CITY OF ALBUQUERQUE

**Re: Winrock-Mens Warehouse
2100 Louisiana Blvd. NE
30-Day Temporary Certificate of Occupancy- Transportation Development
Transportation Development Final Inspection**
Engineer's/Architect's Stamp dated 02-19-18 (J19D058F)
Certification dated 07-19-18

1 ARCHITECTURAL SITE
SCALE: 1" = 10'-0"

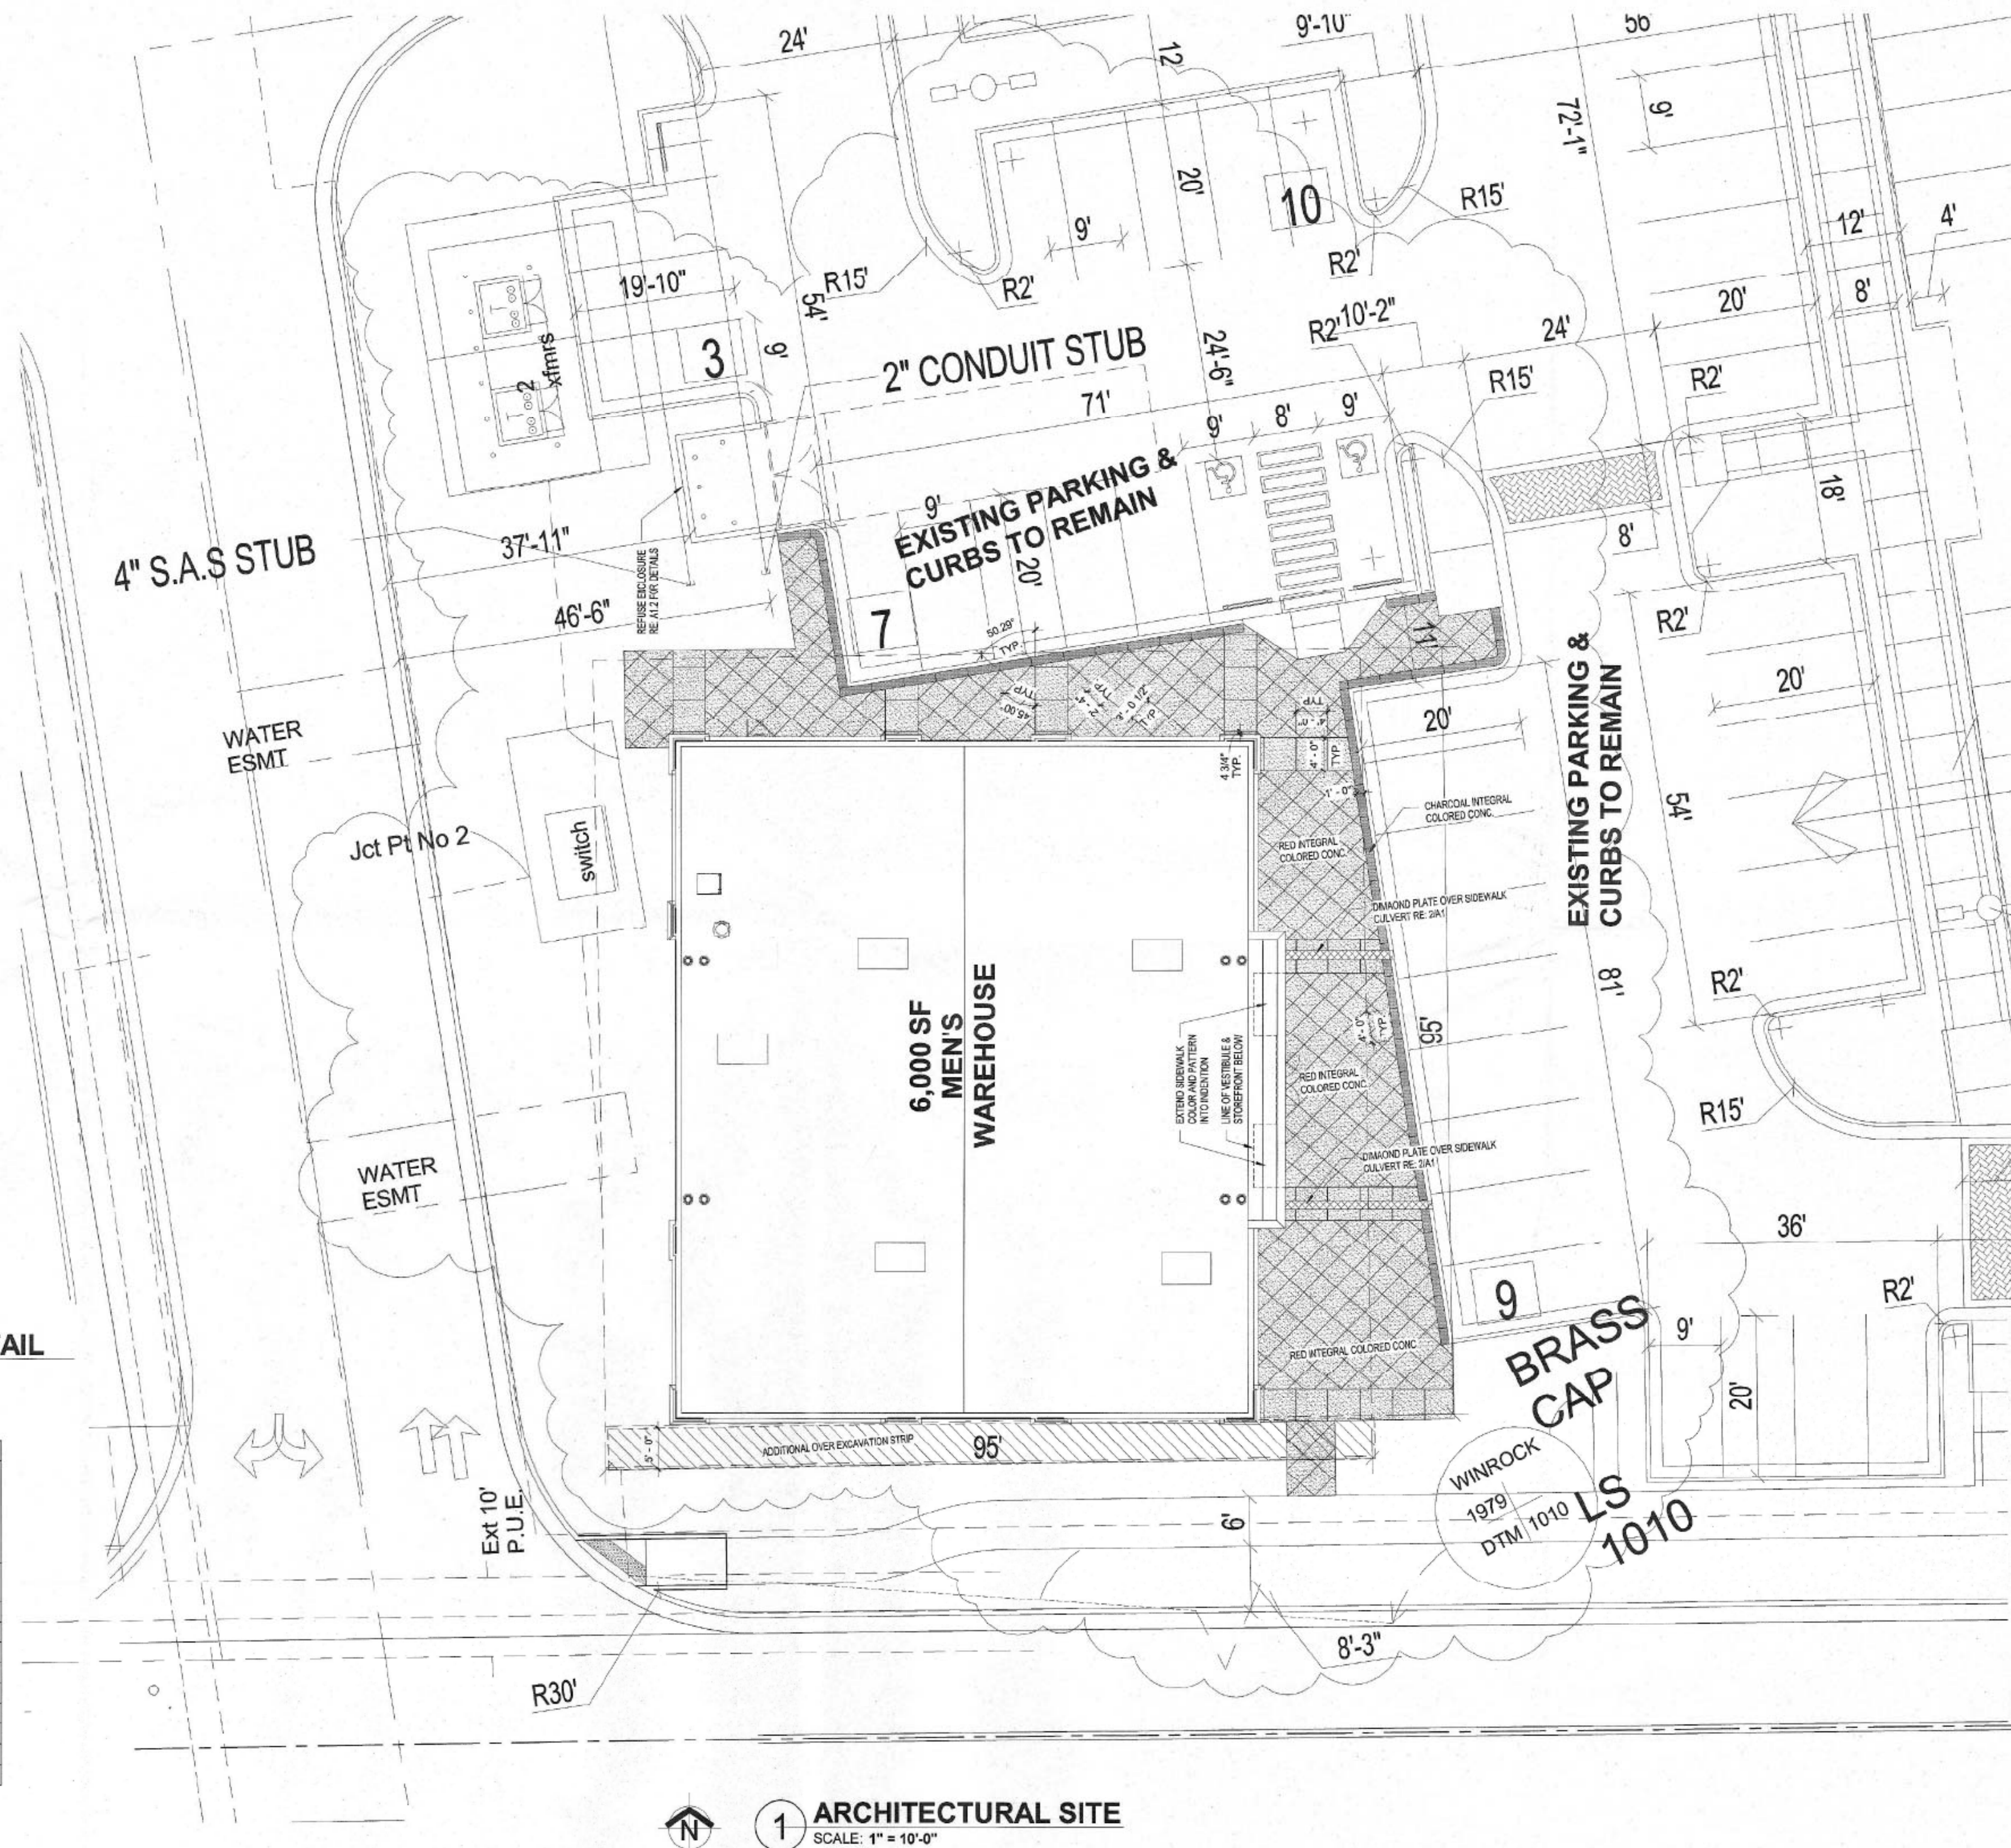
1. Build Sidewalk Connection.
2. Add "No Parking" marking to ADA access aisle.
